11 December 2015

Amy Wilson
Team Leader Metropolitan Projects
Department of Planning and Environment
GPO Box 39
SYDNEY NSW 2000

Re: Exhibition of State Significant Development Application for Staged Commercial Precinct, West Hoxton (SSD 6407)

Figure 6.1. Upstream Catchments & Proposed Management

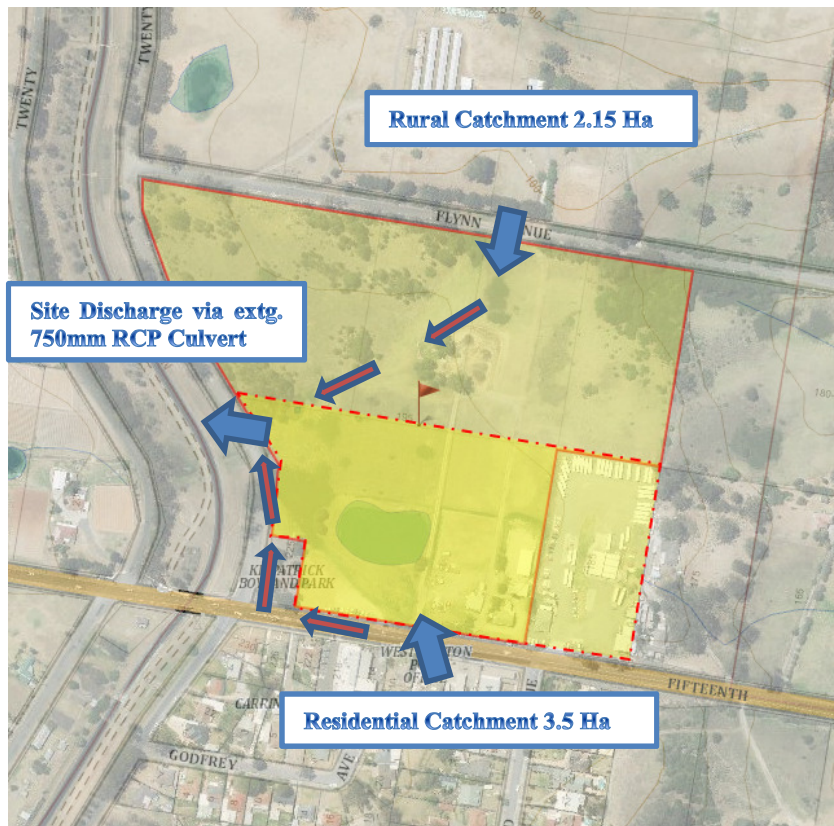
The Environmental Impact Statement and associated site plans indicate a proposed stormwater detention basin within the western portion of the site (proposed Lot 7 of the subdivision). It appears that these works are beyond the extent of the assumed development area assessed by the Flora and Fauna Assessment (FFA) (i.e. subject site, as indicated in Figure 1 of the FFA).

It is recommended that the FFA is reviewed to ensure that it considers all impacts associated with the current plans, including the proposed detention basin. It is further recommended that any conditions of consent issued include the requirement for any works or activities to adhere to the recommendations of the FFA.

CONCEPT CIVIL WORKS PLAN
SCALE 1:500

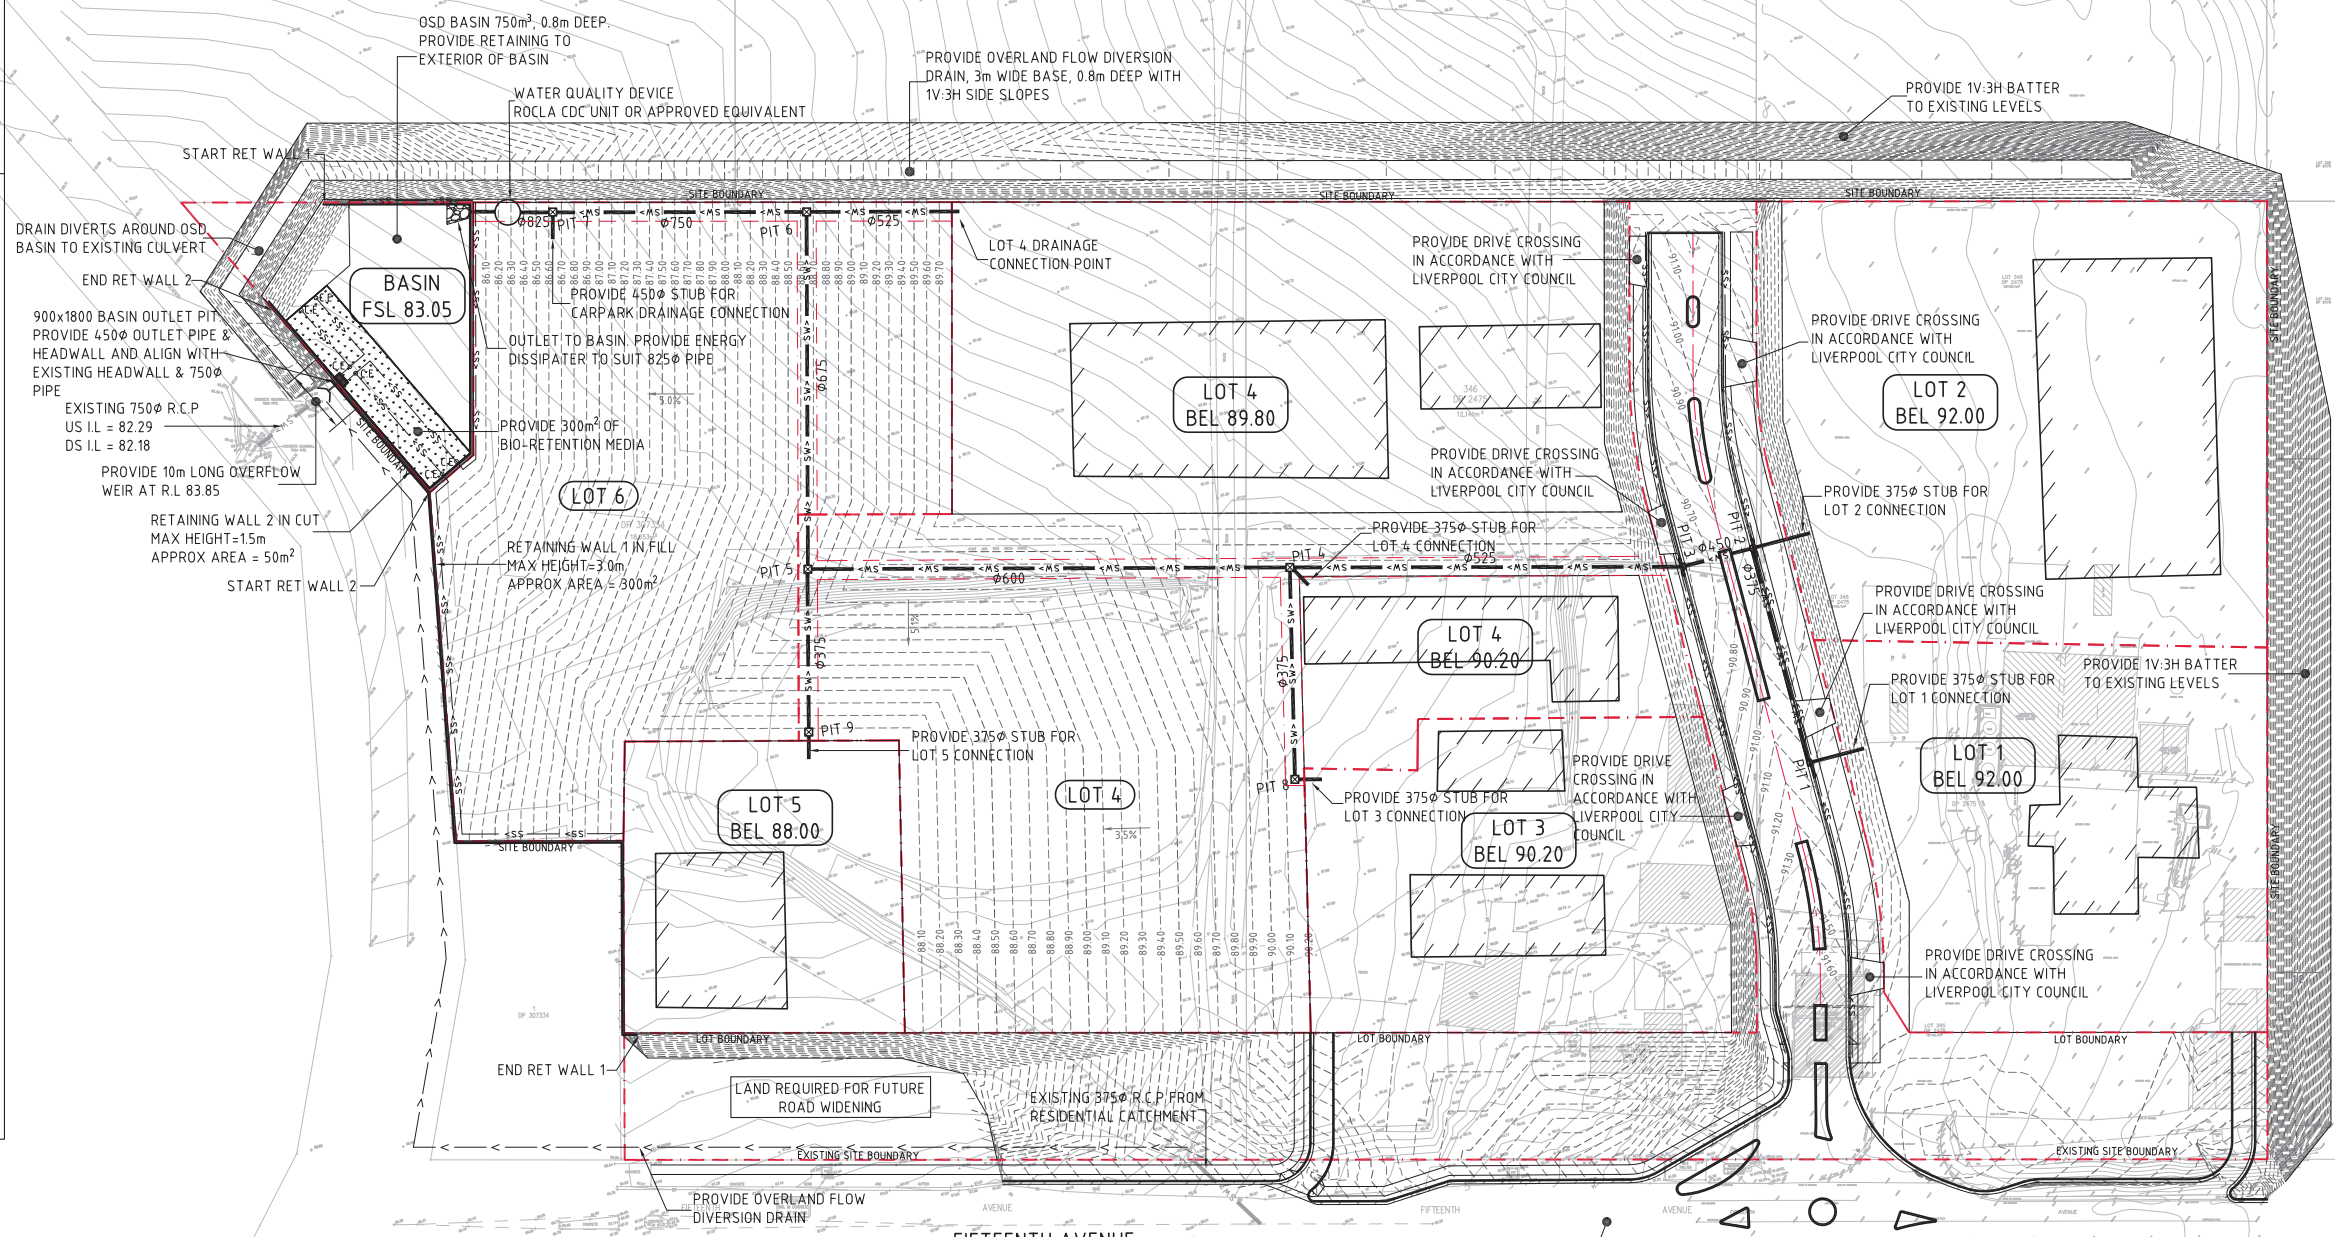
The traffic impact of this development would be along the section of Fifteenth Avenue fronting the development site. To cater for the turning movements in and out of the development the development is proposing a roundabout at the cross intersection of Fifteenth Avenue/Twenty Second Avenue/ Access Road to the site as well as the following:

- A left-turn deceleration lane for the service station
- A left- turn deceleration lane into the fast food development

The provision of a signalised intersection has been assessed as infeasible at this intersection by the applicant. It is recommended that more information on this assessment, including SIDRA analysis for signals, is to be sought from the applicant for further assessment by Council and the RMS prior to any approval being issued.

The installation of a roundabout was discussed with Council and the applicants were advised that the roundabout should only be considered as an interim treatment. The future cost for upgrading the roundabout to traffic signals is to be borne by the applicant. This recommendation was discussed with the applicant before RMS started design investigations along Fifteenth Avenue.

It is further recommended that the intersection treatment is discussed and agreed to with Council and the RMS prior to determination of the application.

1. A preferred intersection treatment including a signalised intersection at Fifteenth Avenue/Twenty Second Avenue/ Access Road to the site (including SIDRA analysis for signals) is to be agreed with Council and the RMS.
2. A referral for the proposal is to be made to the RMS and their comment taken into consideration.
